CITY OF ALBUQUERQUE

December 5, 2023

**Re: Meineke Car Care
5901 Carmel Dr NE
Request for Certificate of Occupancy- 30 Day Temp
Transportation Development Final Inspection**
Architect's Stamp dated 9-22-20 (C18D049)
Certification dated 11-21-23

C3 BIKE RACK ELEVATION
1/2\"/>

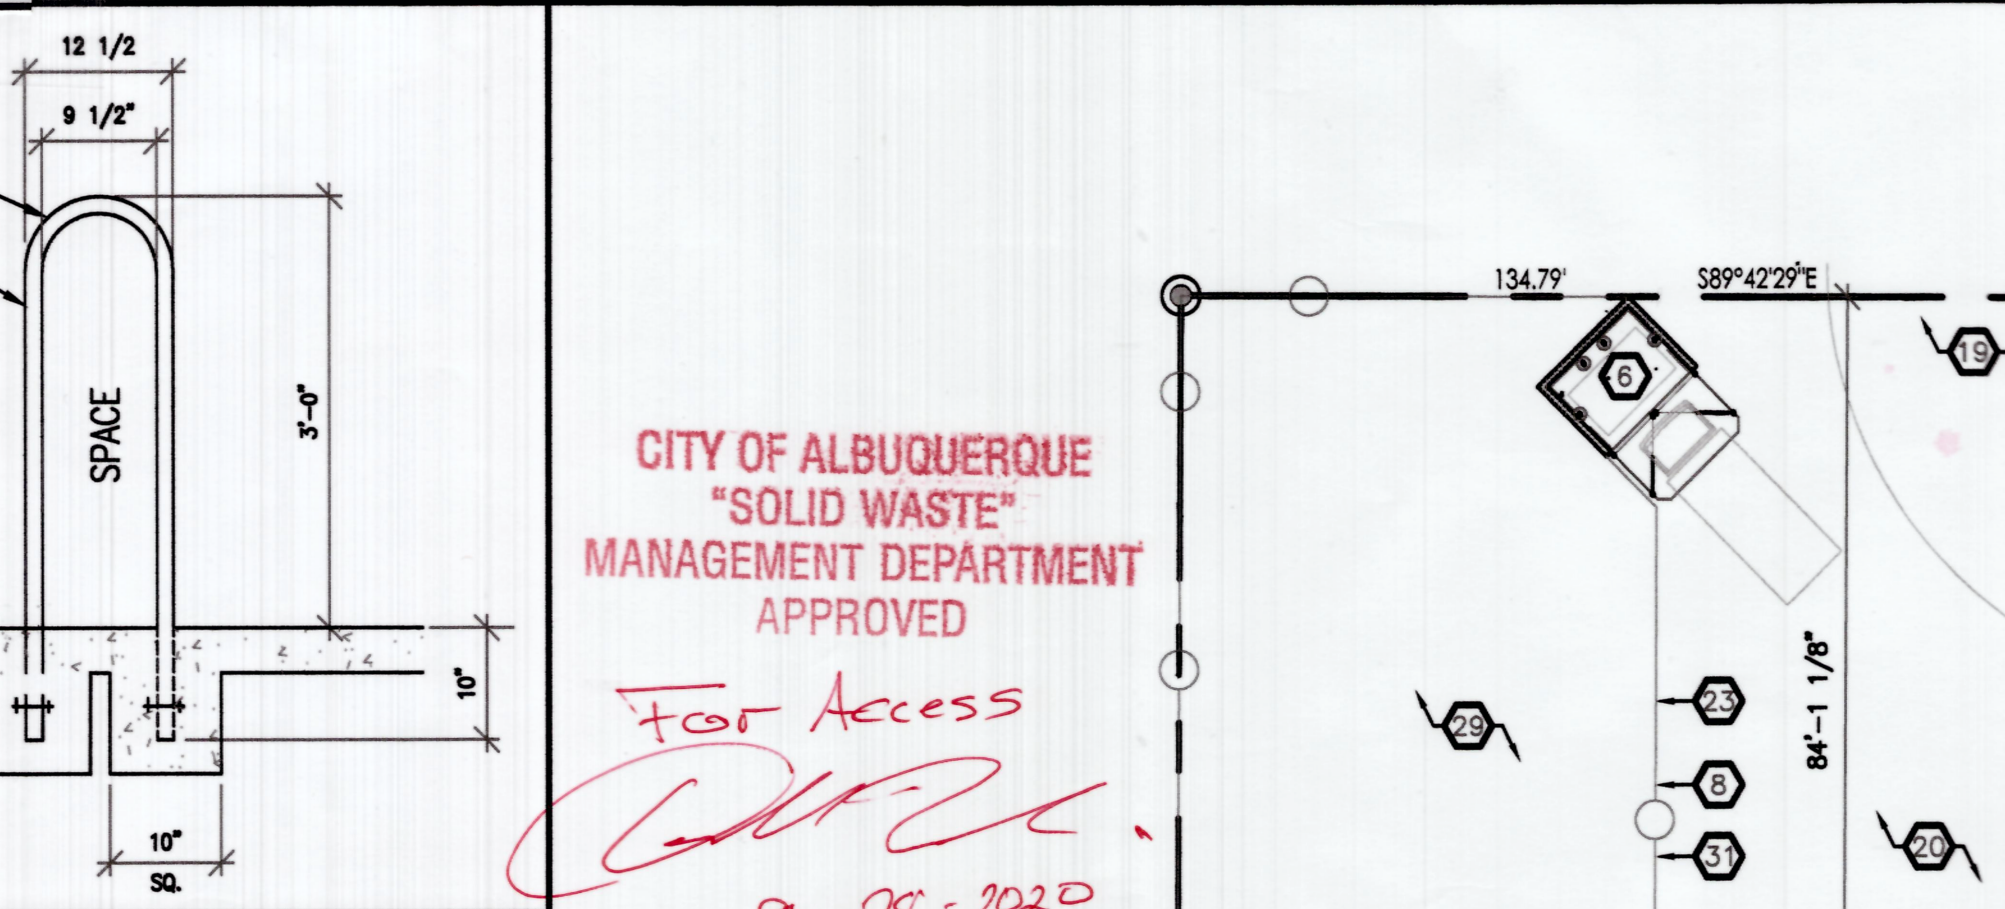
1. The sidewalk connection to the San Pedro ROW is to be built as this is the ADA pathway for the site as shown on the approved plan.
2. Provide three bicycle parking spaces. Currently, there is one wave-style rack, which offers the possibility of providing two bicycle spaces. However, users may attempt to park perpendicular to a wave style rack as this is the intention of the manufacturer. The type of bike rack and the layout of the racks shown on the approved plan is a better style bike rack/layout as there is no confusion on its use.
